**Re: PA22-024- Marysville 44th PRD – Technical Review 1
7315 / 7417 44th St NE – APN(s) 30053500303700 / 30053500303600**

This letter is provided as response to comments dated August 17, 2022. Each item has been carefully reviewed and considered and the following is a summary of how each item was addressed.

DRAWING: **C3**
 SHEET: **3** OF **9**

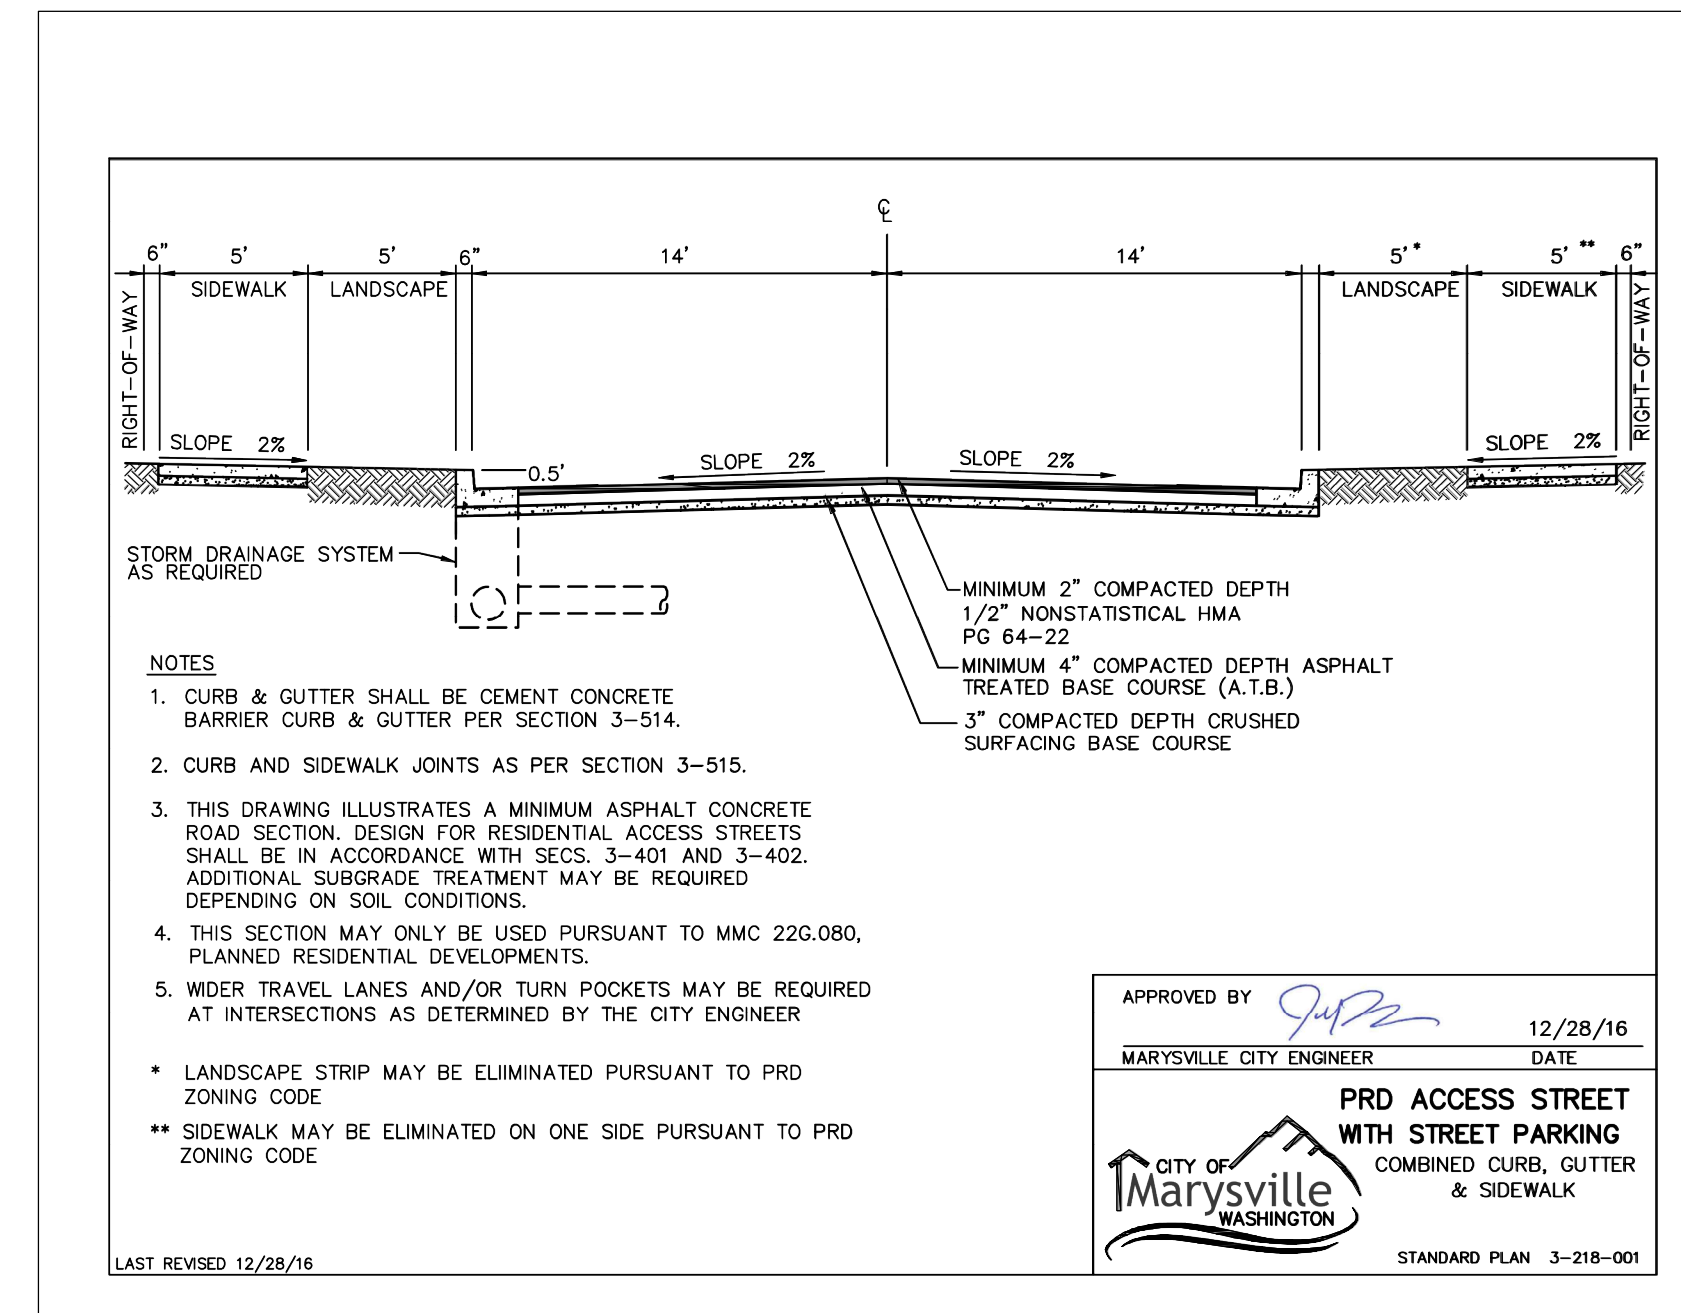
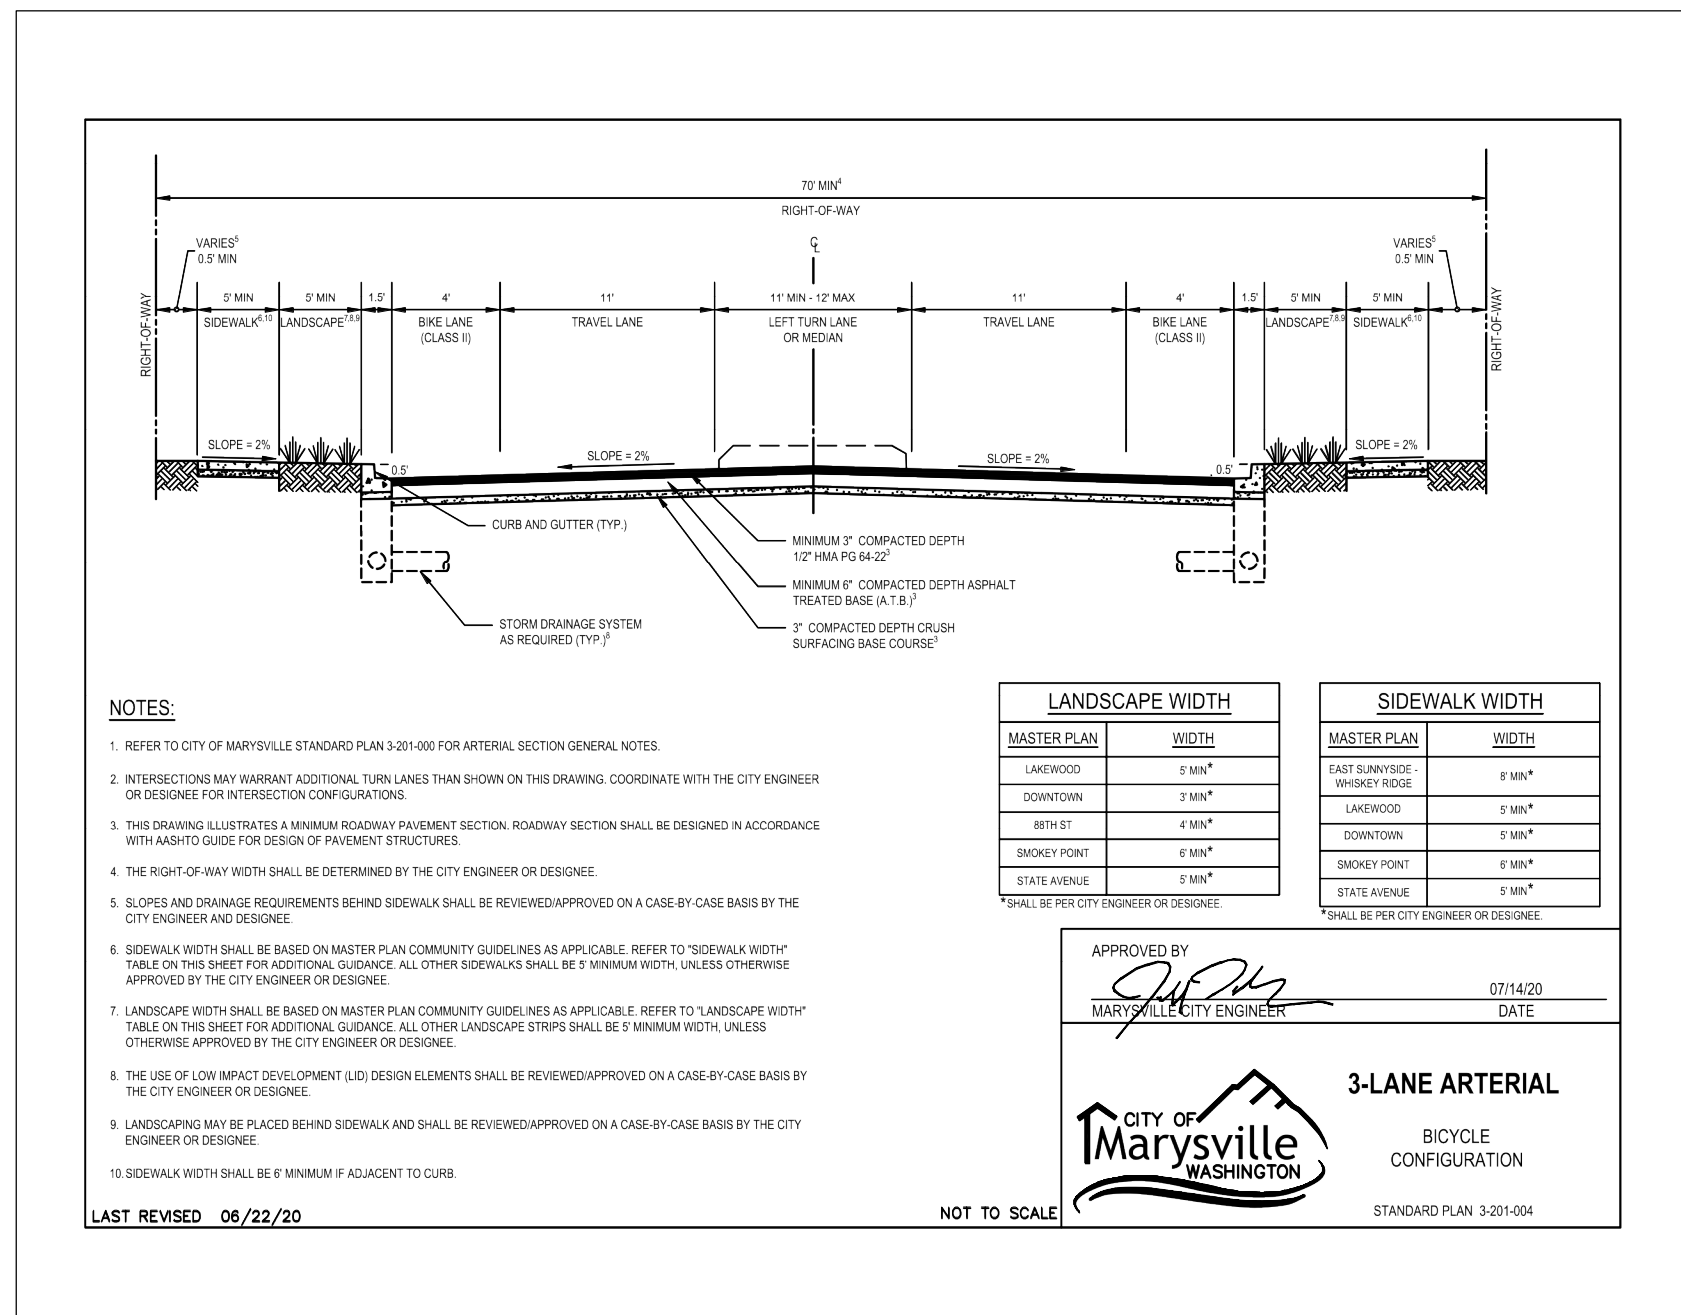
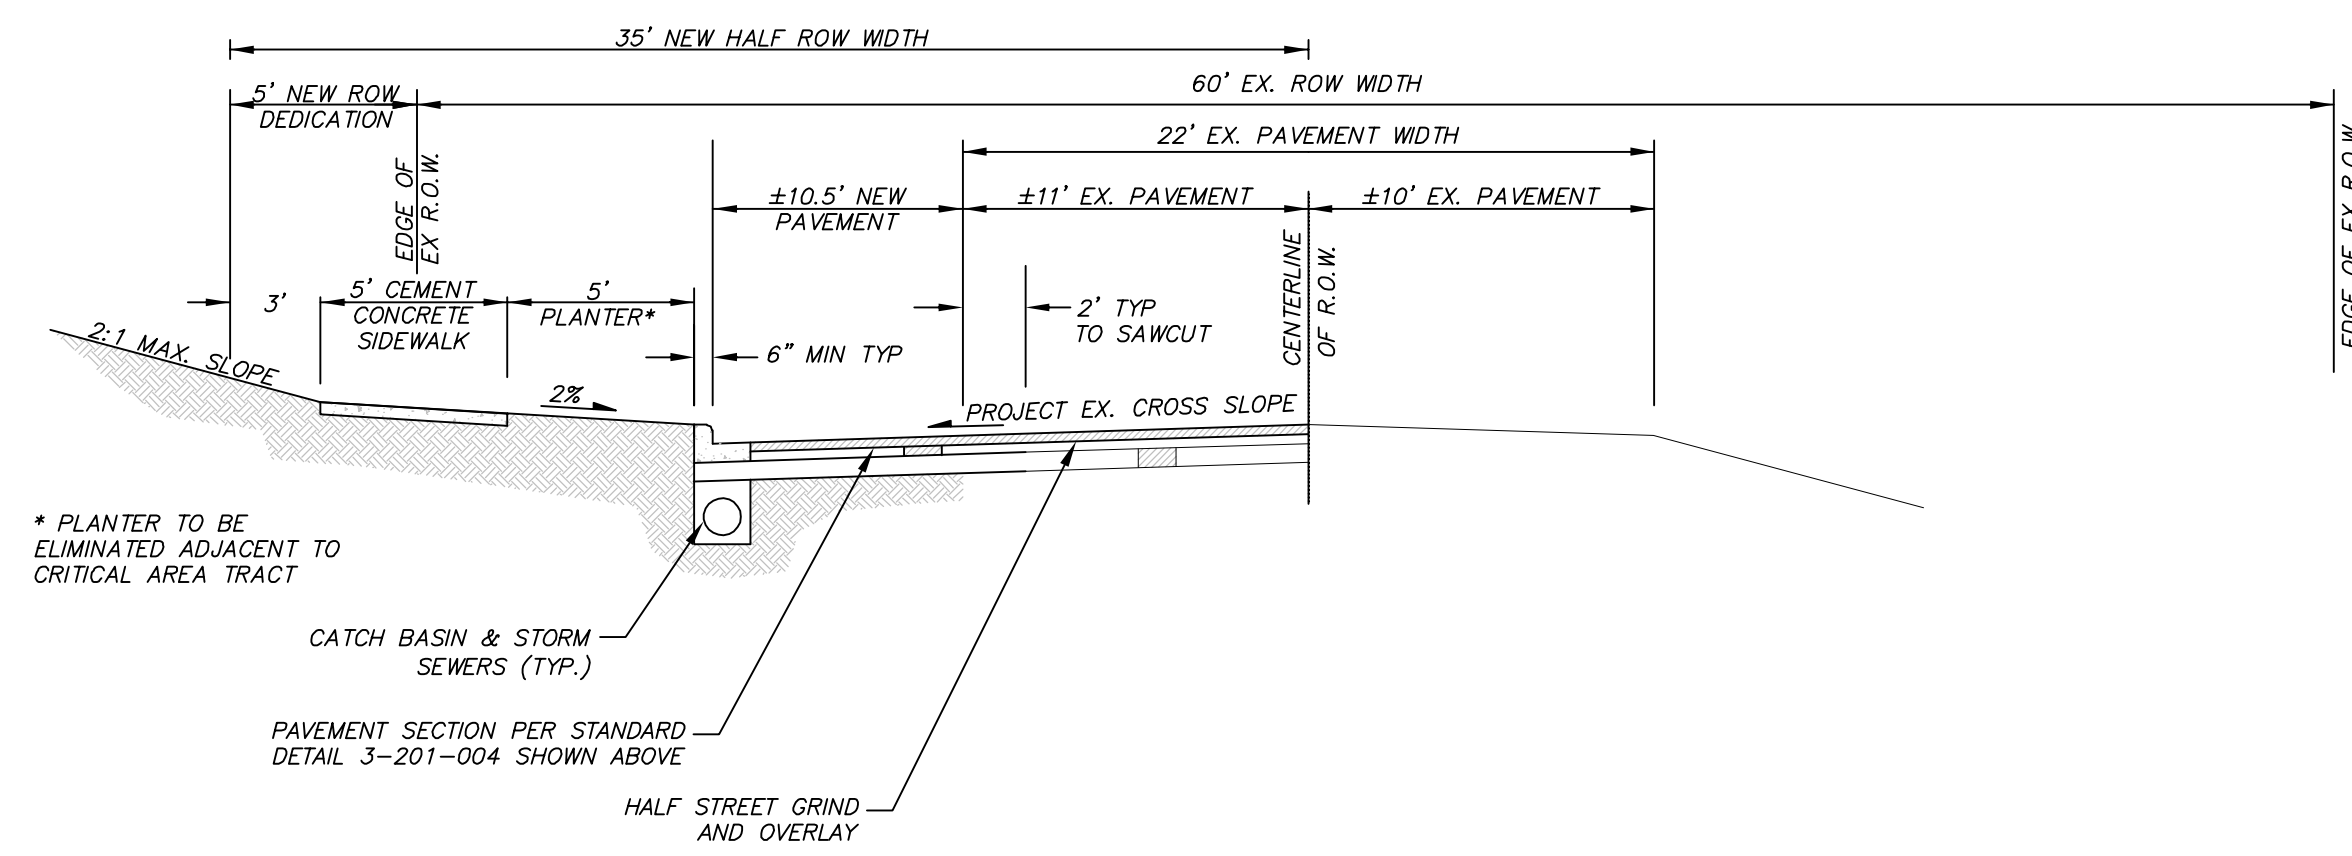
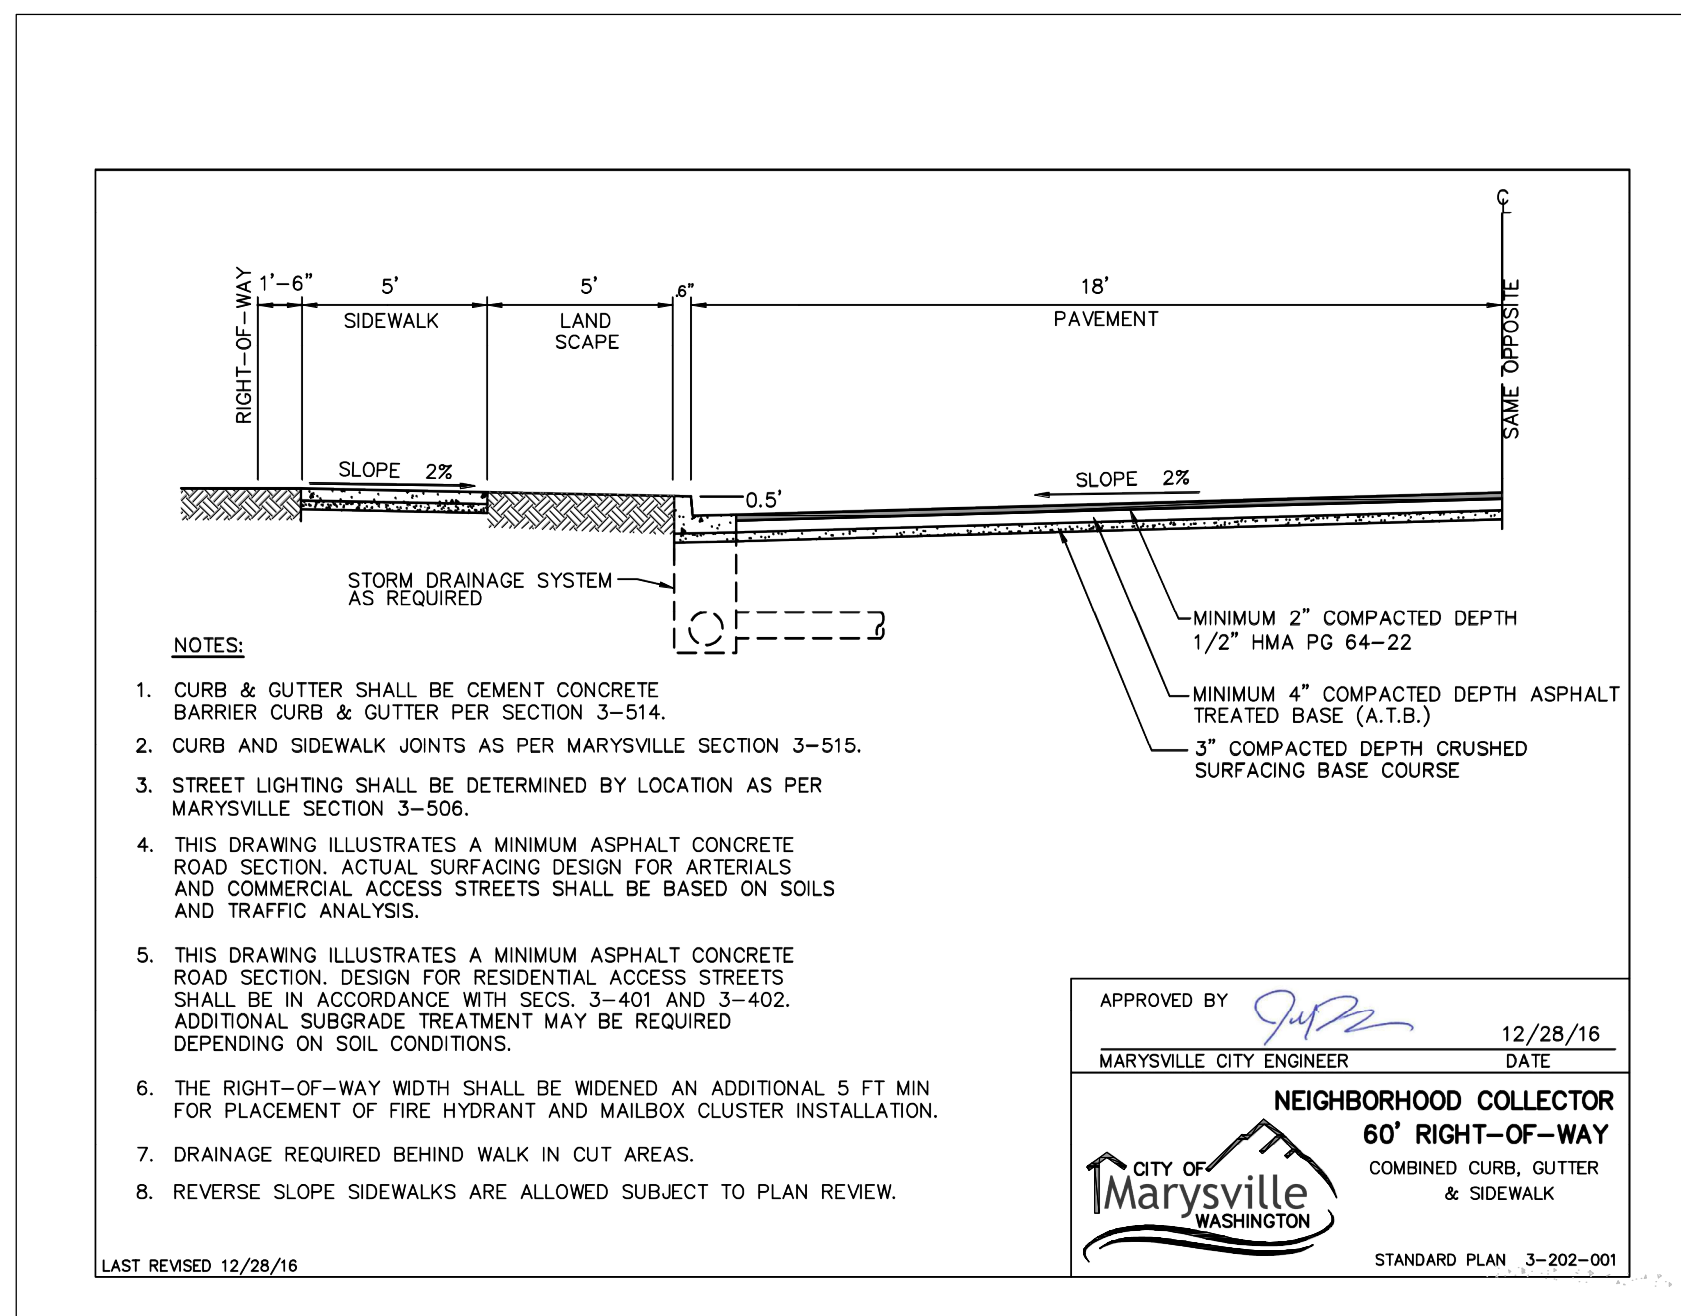
- f. Even though 75th Ave NE will only be built as a half street it still must be built per SP 3-202-001, including a planter strip, matching the development to the north.

Revised.
